Application for a non-material amendment following a grant of planning permission.
Town and Country Planning Act 1990

ERECTOR OF SINGLE STOREY FRONT EXTENSION, INSTALLATION OF NEW OPENING & ASSOCIATED ALTERATIONS

2024/62/93334/E

ENLARGEMENT OF PROPOSED SIDE (NORTH ELEVATION) WINDOW

North Elevation
(side)

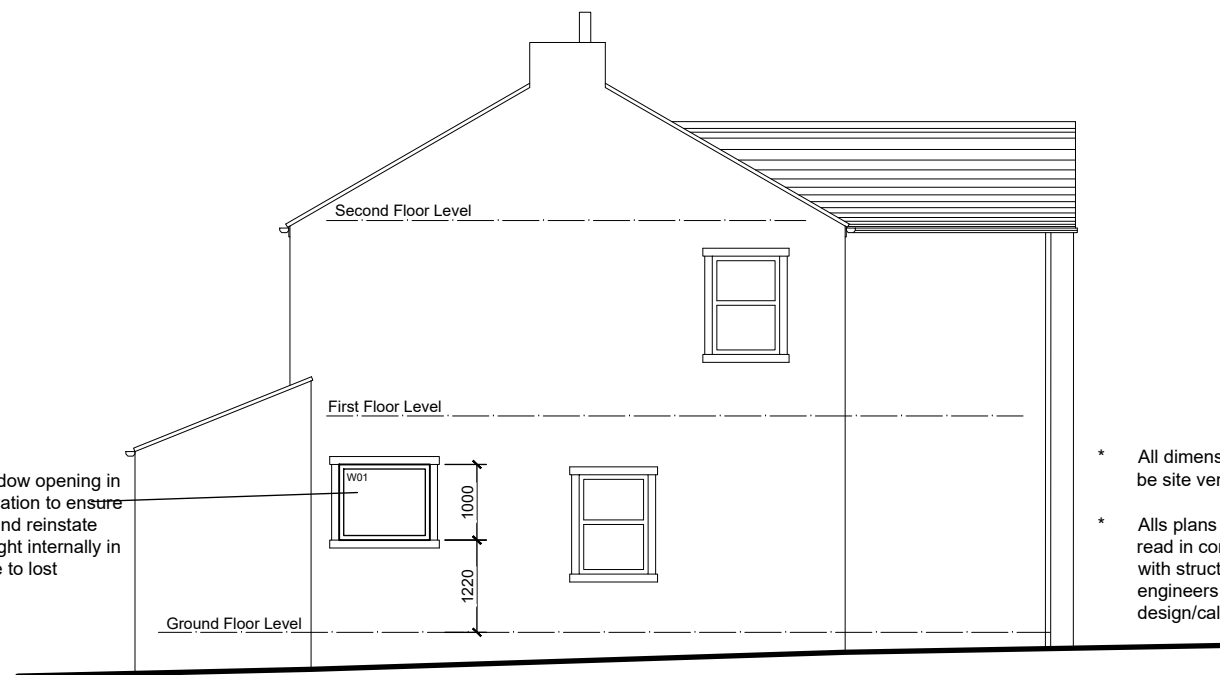
CREATE MORE NATURAL LIGHT TO MAIN BODY OF EXISTING DWELLING

24/972/06A & 07A
